CITY OF ALBUQUERQUE

July 13, 2023

Re: Markana Flats
7050 Constitution Ave. NE
Conceptual Traffic Circulation Layout
Engineer's/Architect's Stamp 6-9-2023 (J19D047A)

Based upon the information provided in your submittal received 6/27/2023, the above referenced plan cannot be approved for DFT Site Plan until the following comments are addressed:

## ARCHITECTURAL SITE PLAN

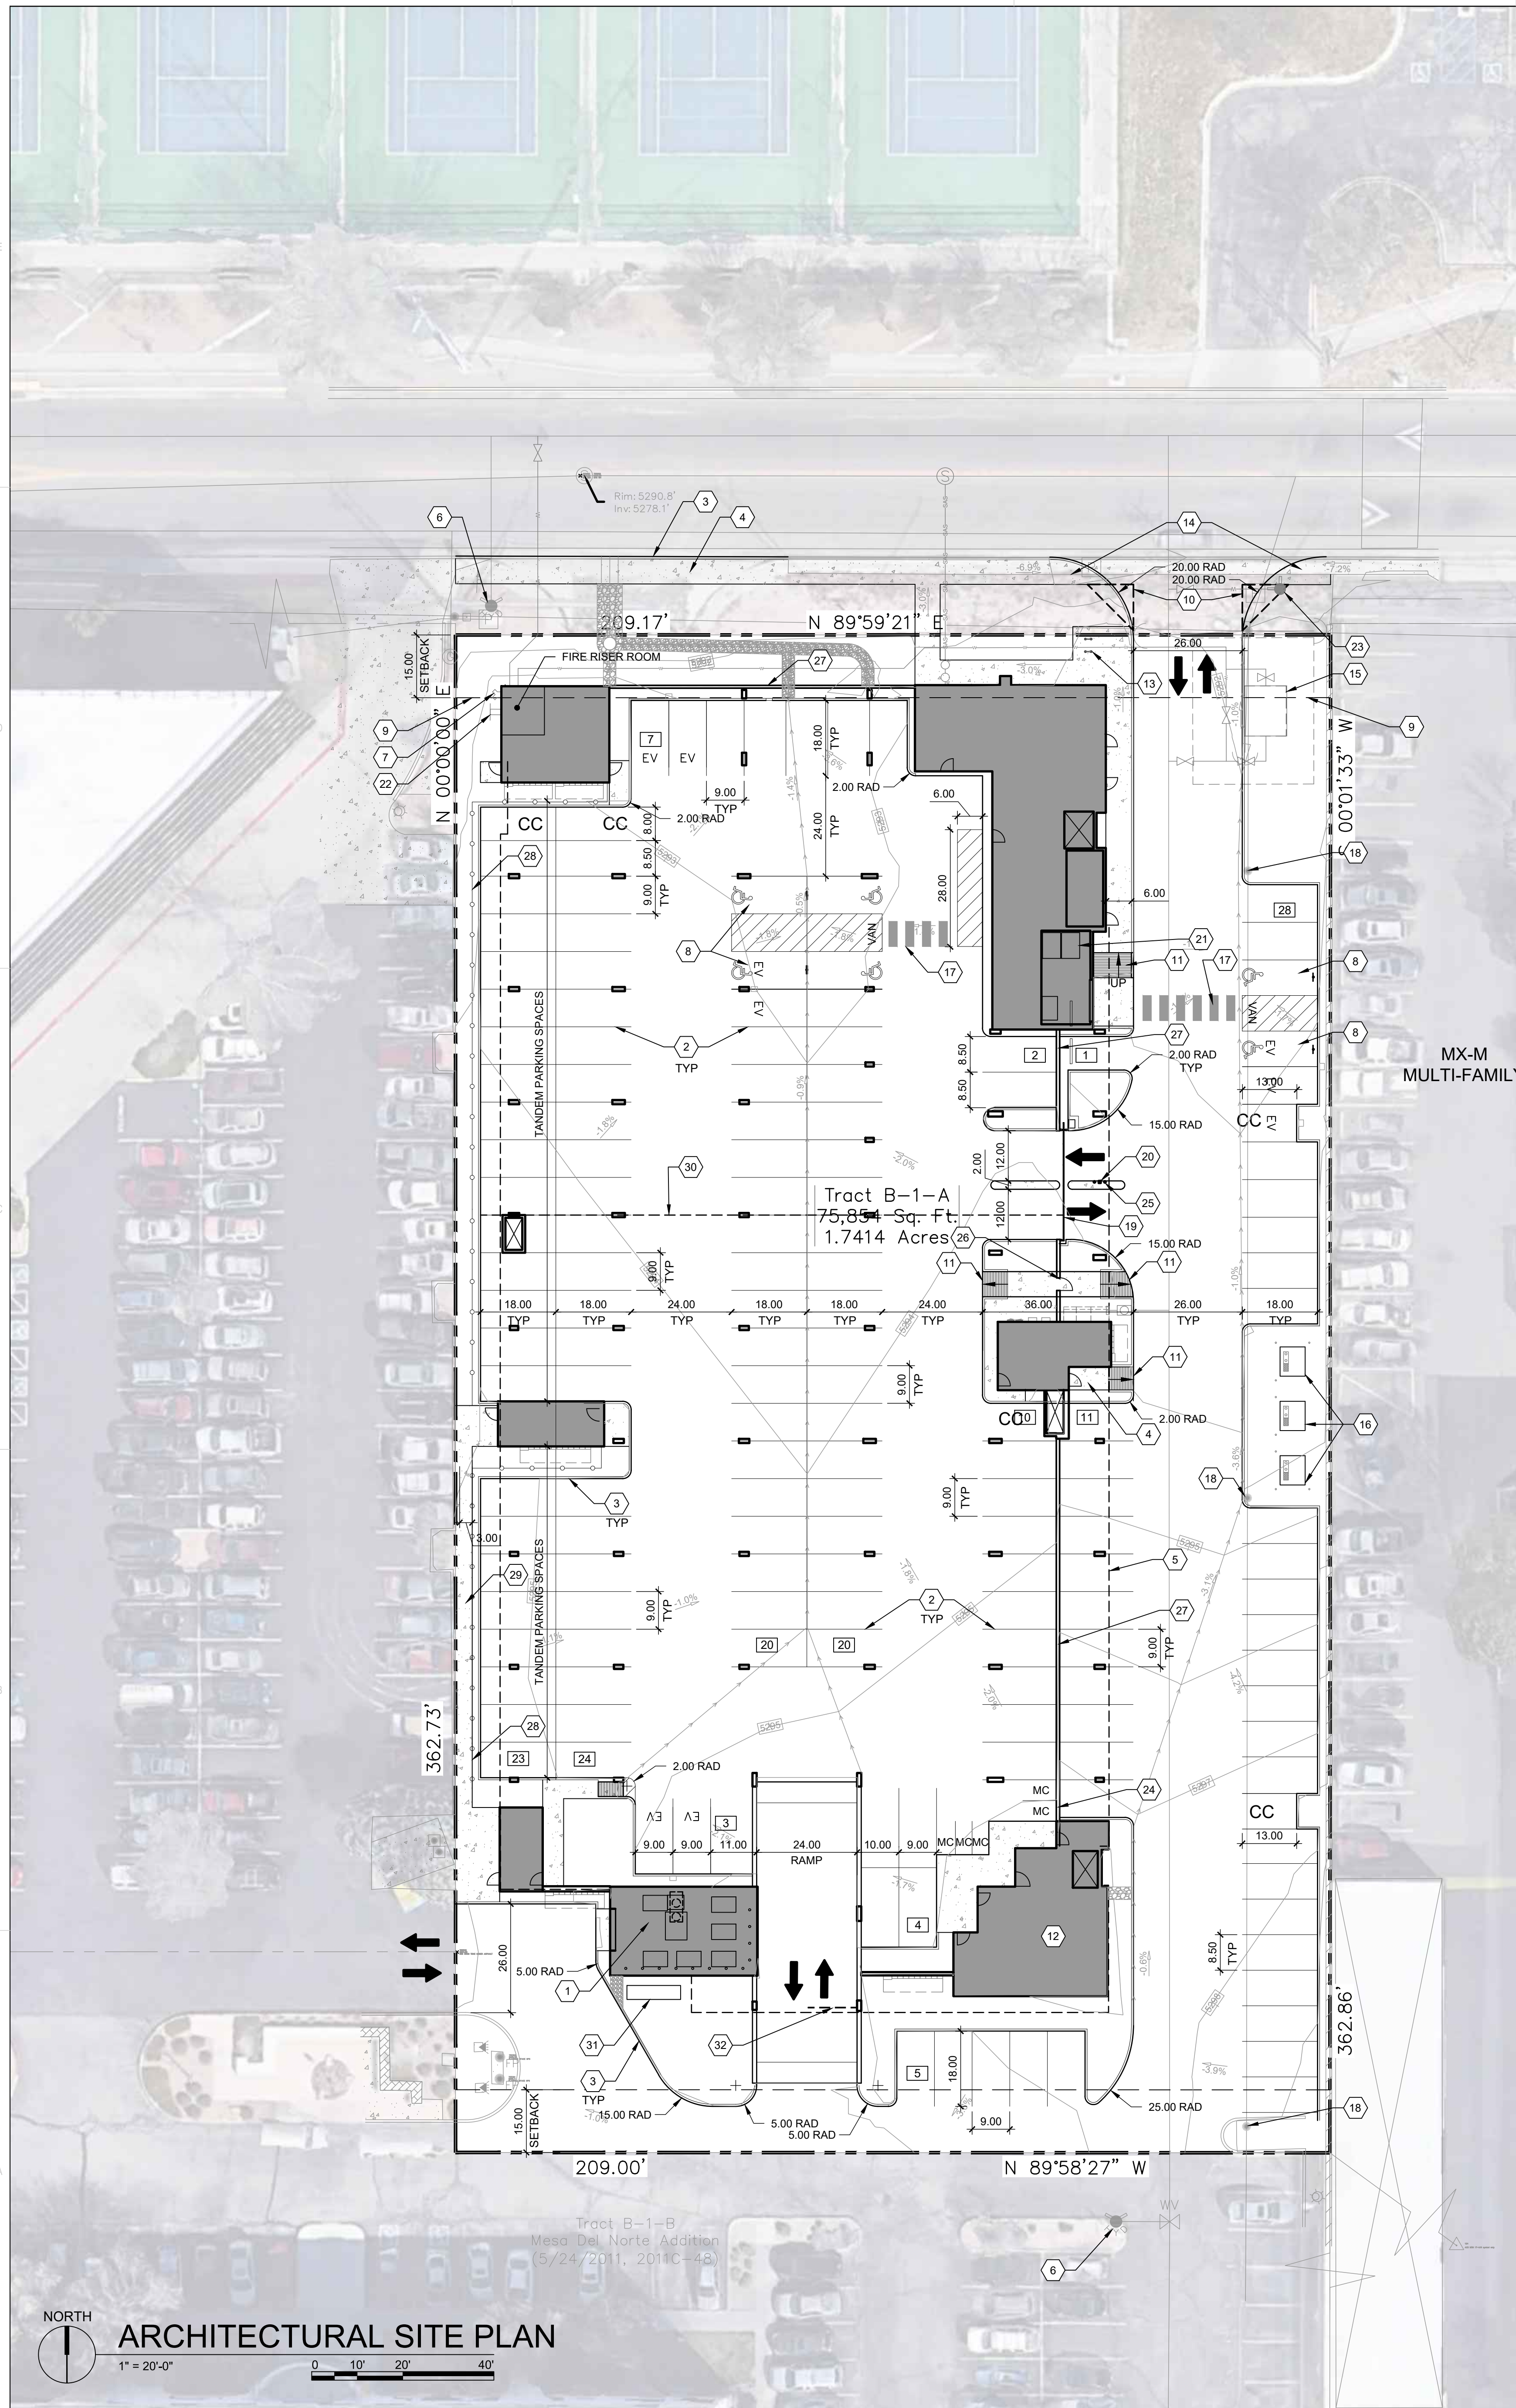
1. It does not appear the design layout will work. You are utilizing 36 tandem parking spaces within the parking garage. You need to provide at least one space per unit which is not a tandem space or you are creating a situation where a resident may have their vehicle blocked in by a separate resident.
2. Your parking calculation show you are providing 19 bicycle parking spaces, but only 2 racks are called out on the plan. Please show all bicycle parking.
3. You will need a cross access agreement between this property and those to the west and south. Please provide this.
